RE: Environmental Assessment for Stage 2A(I) of the City East Zone Substation Development

We write in response to the Environment Assessment lodged with the Department of Planning in relation to the proposed City East Zone Substation development at 33 Bligh Street, known as Kindersley House.

My client, ACE Insurance Limited, is the owner of 28-34 O'Connell Street, Sydney (known as 40 Hunter Street in the Environmental Assessment) which is immediately adjacent to the proposed development site.

Figure 6-1 Indicative location of hoardings

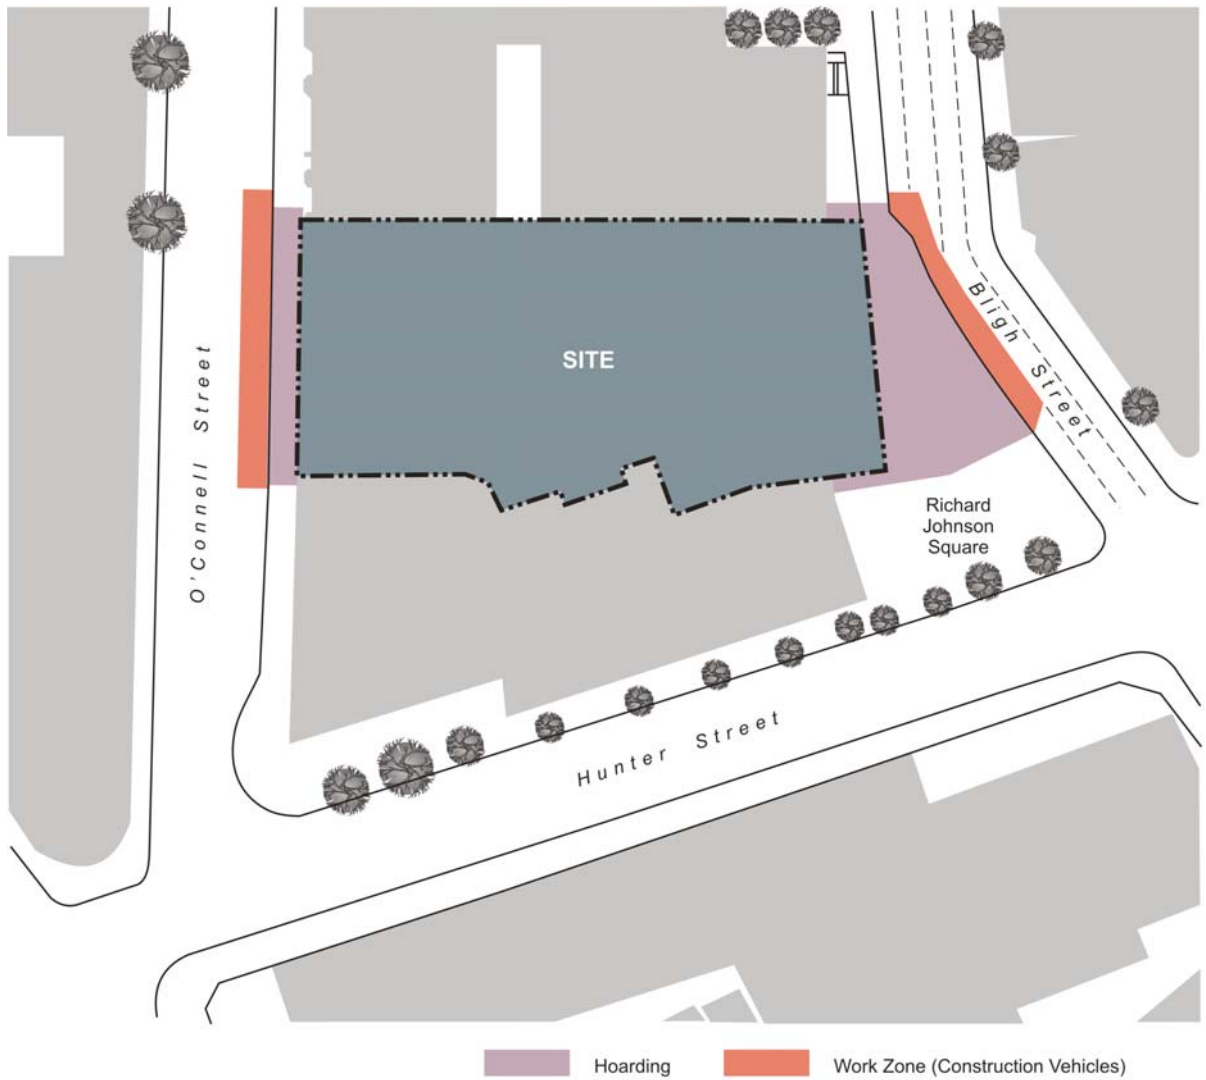
During the demolition and construction works we understand a Class B structural hoarding will be constructed to protect the public using O'Connell Street. We would like to further understand the proposed positioning of the hoardings as it is imperative that a clear line of sight and clear access is maintained both into the entrance of 28 O'Connell Street, the vehicular entrance to the basement car park which is utilised by ACE, its tenants and the tenants of 44 Hunter Street and also the entrance into the coffee shop within 28 O'Connell Street.
